80 Sandgate
Blackpool
FY4 2LX

Application No 21/0003

With reference to our telephone conversation please find enclosed our objections as listed below:-

A1- P02

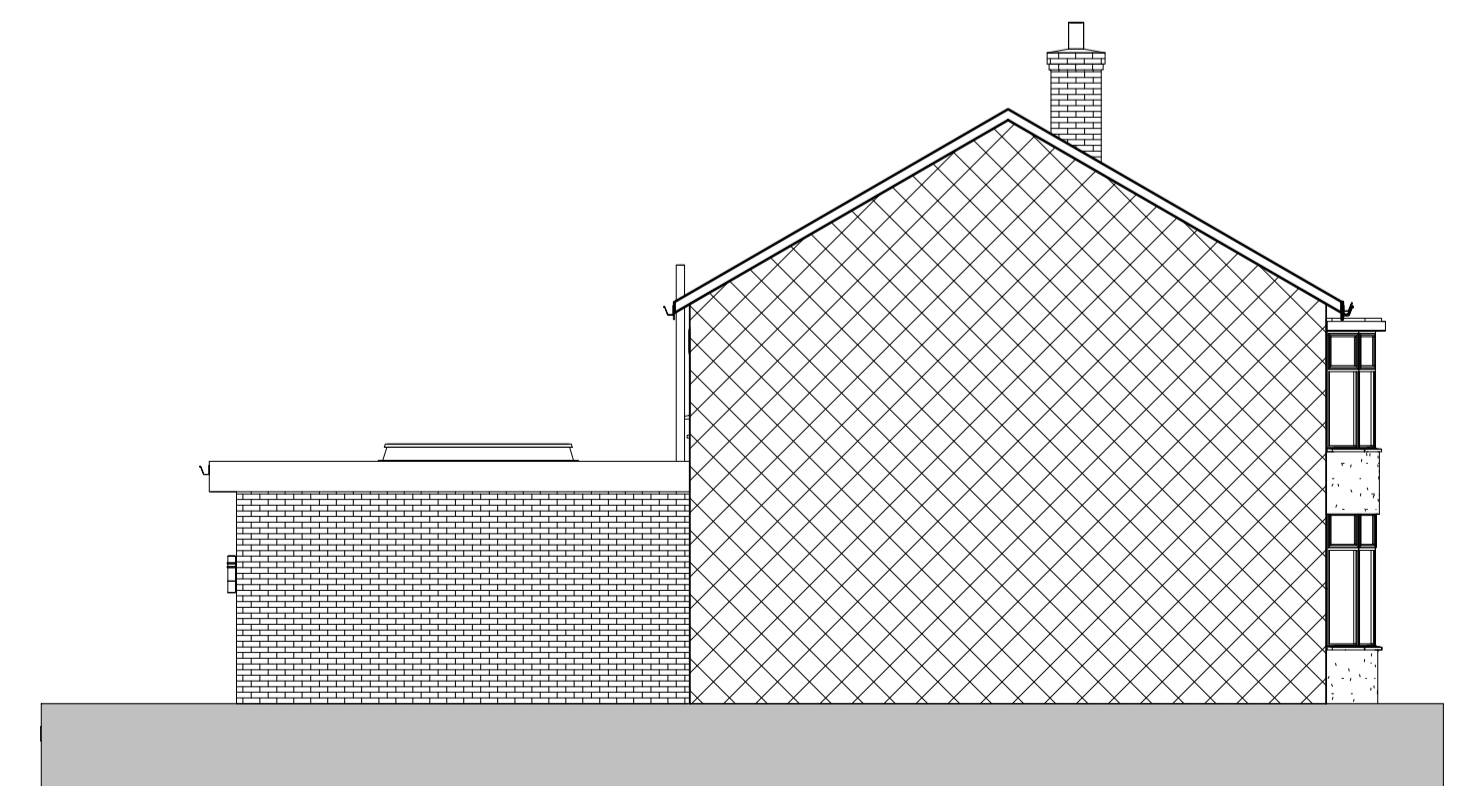
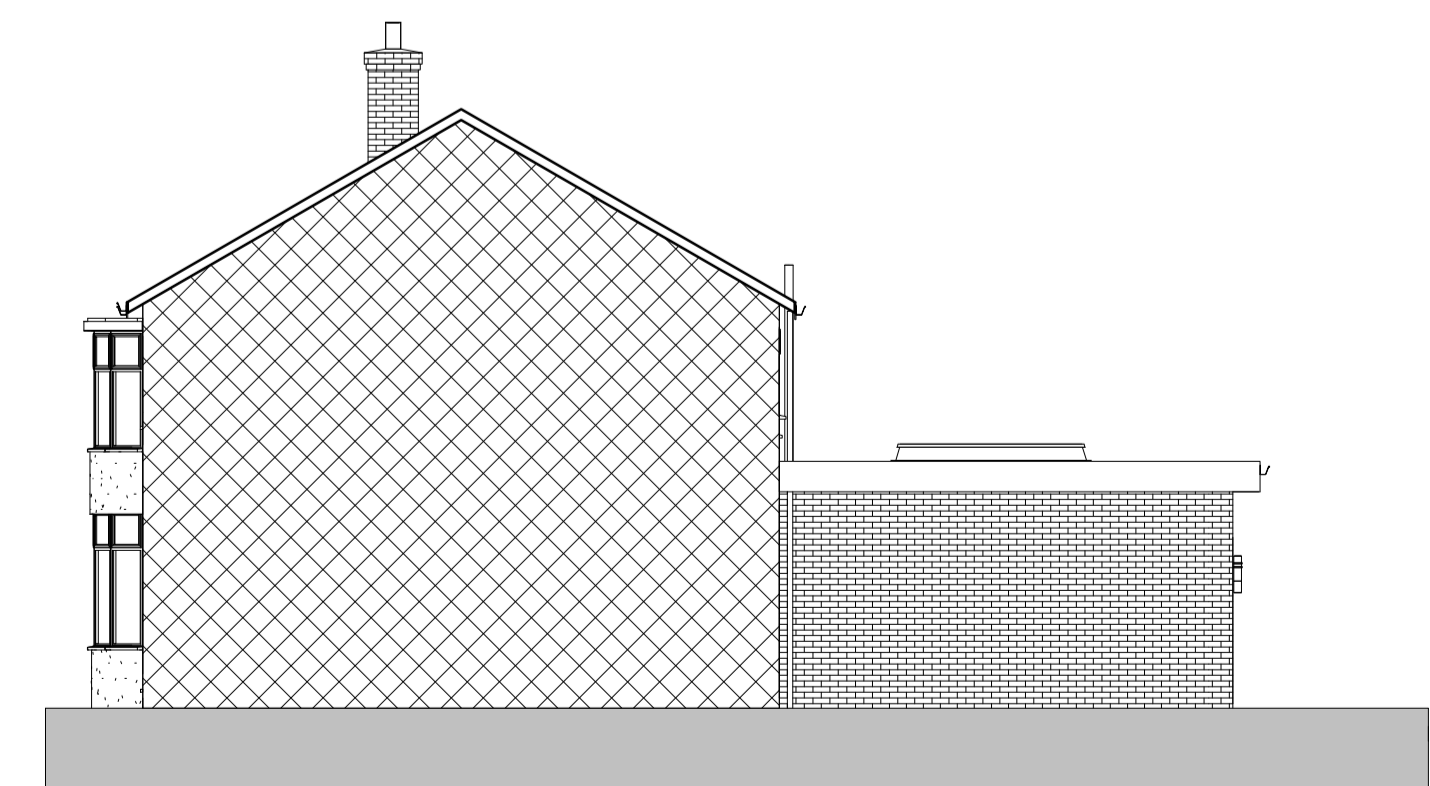
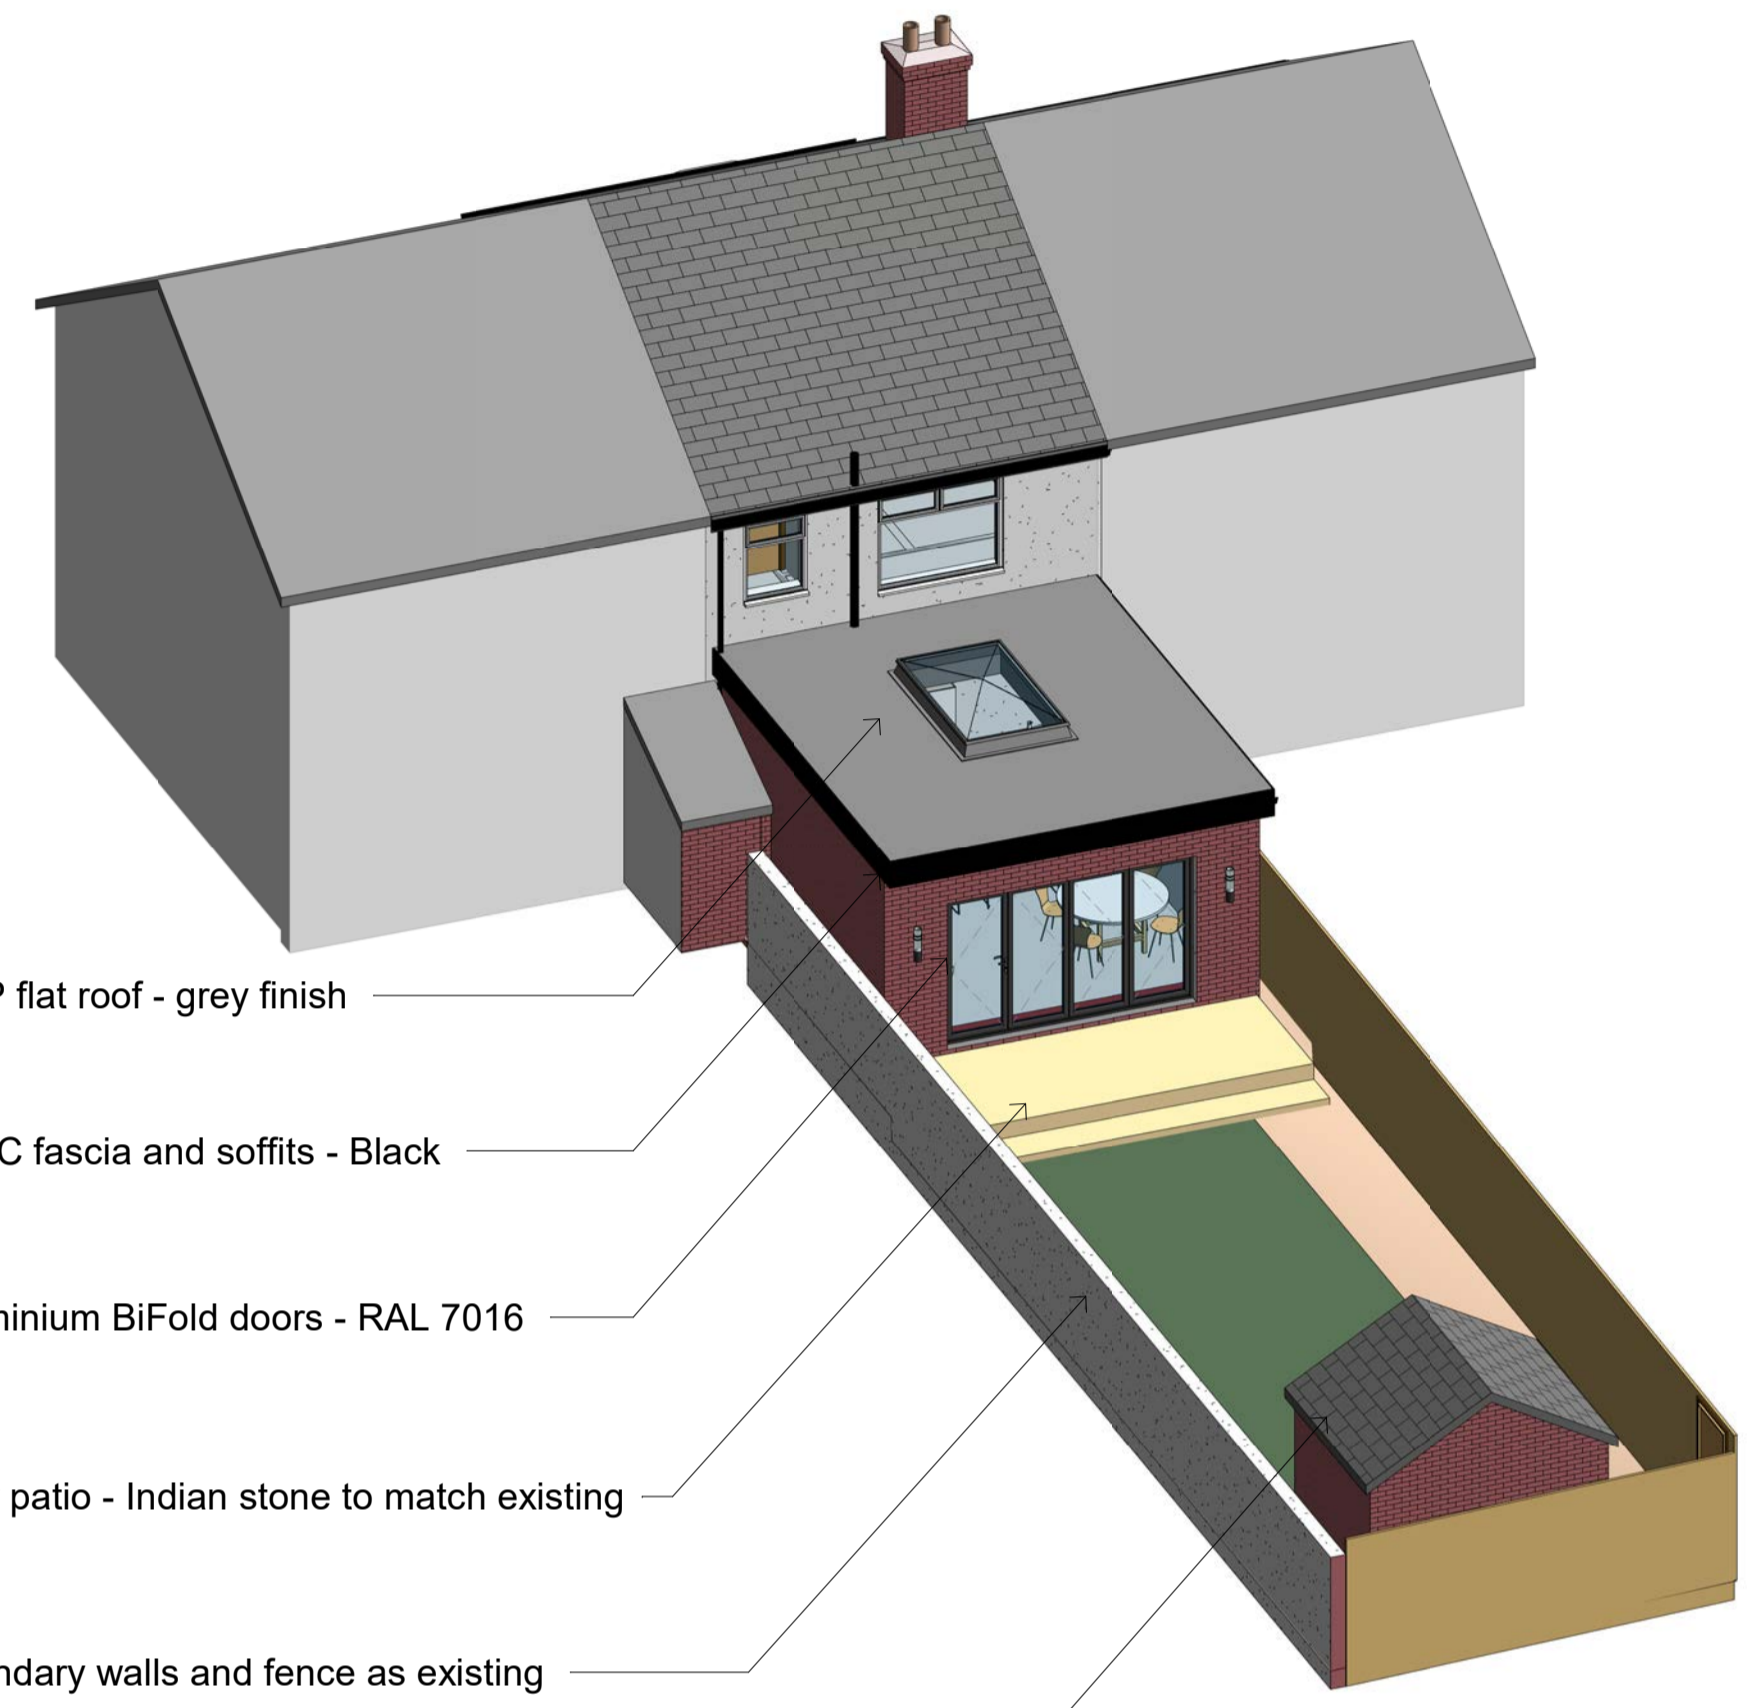
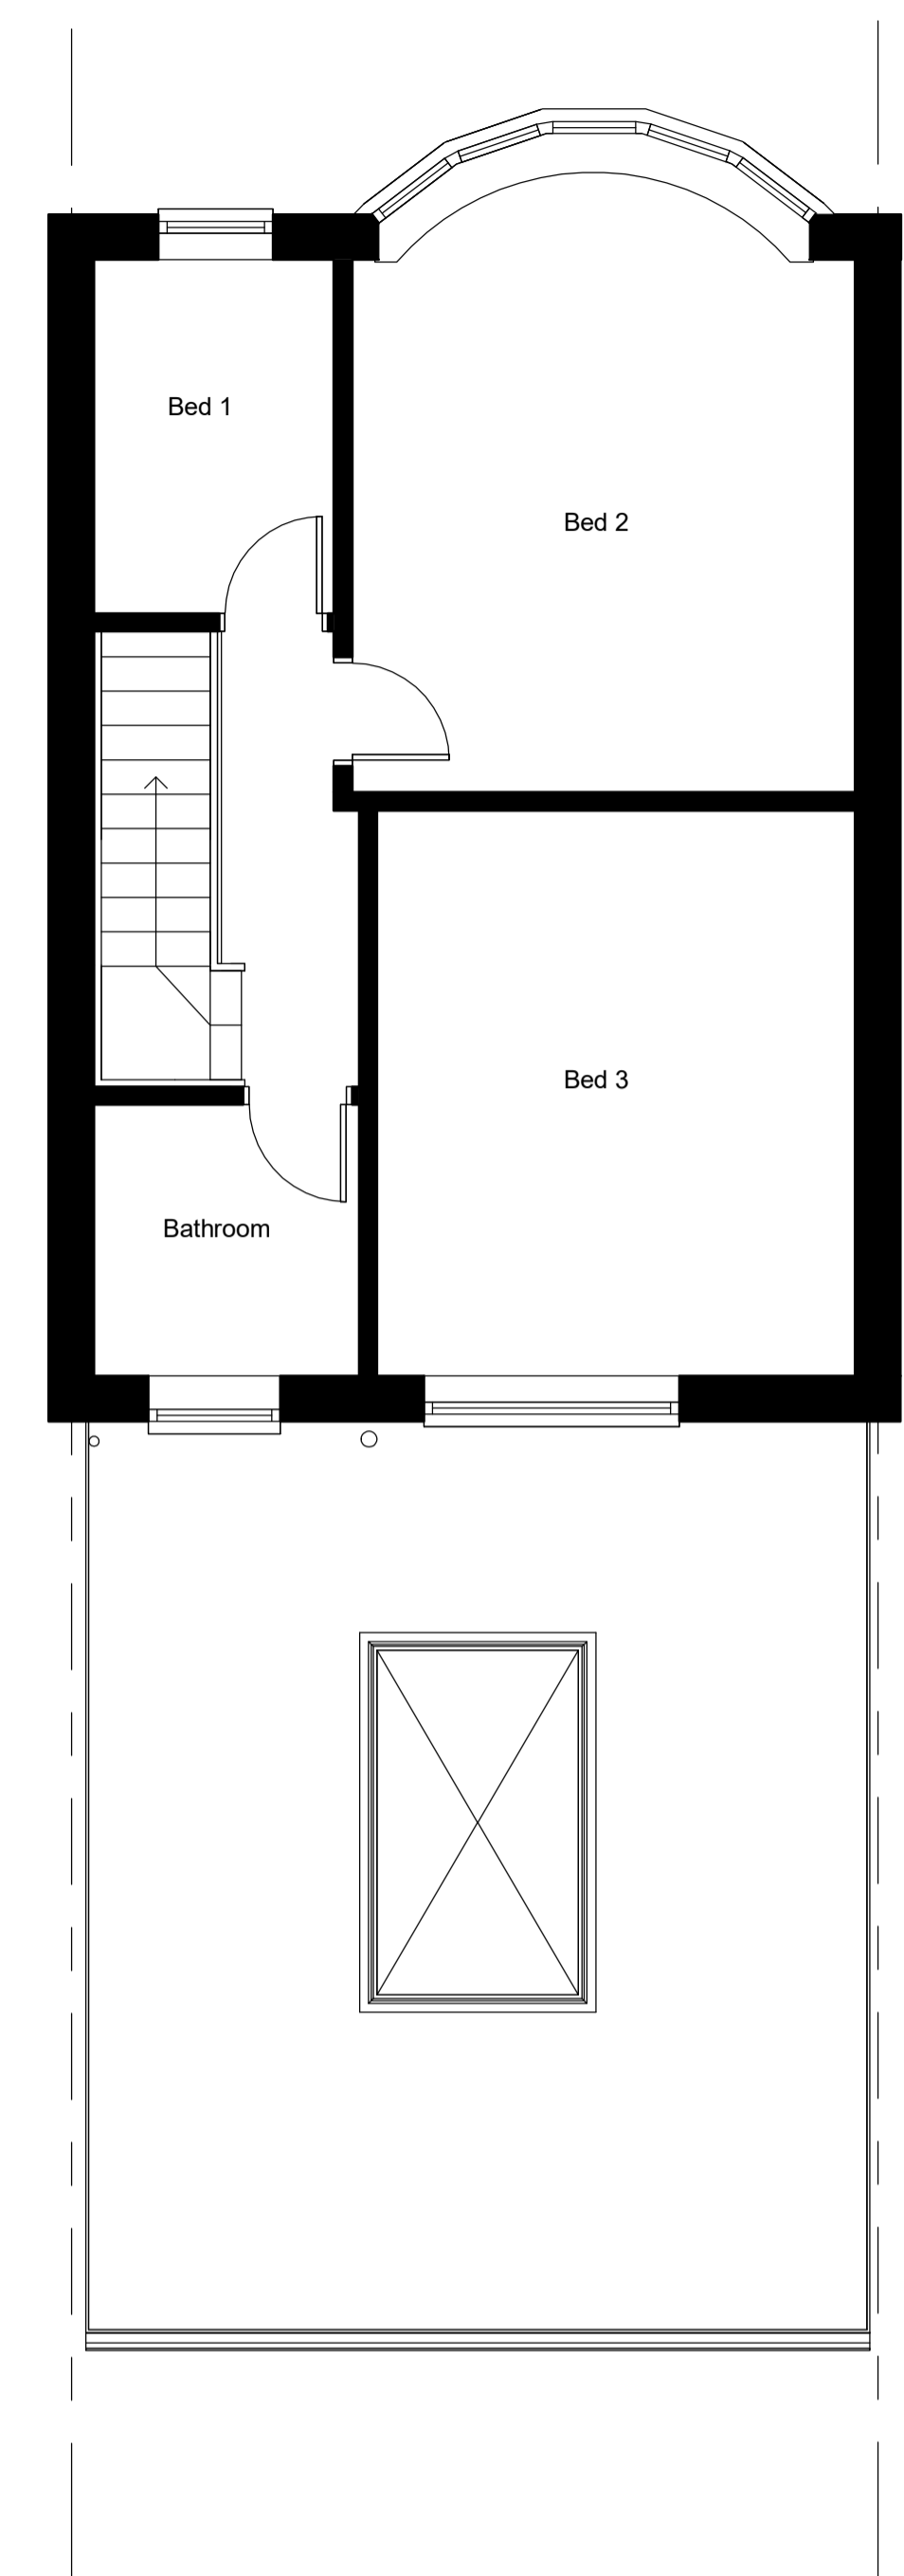
The proposed plans would take all our light and garden would nearly always be in shadow and the price of the property would be affected, Our existing conservatory which is 2 metres from house would receive no sunlight and also the garden from approximately mid morning. Amenities – fish pond and flower bed and lawned garden.

Their extension which is 6 metres long and 3.25 metres high would block all light and would be approximately 500mm higher than our existing conservatory.
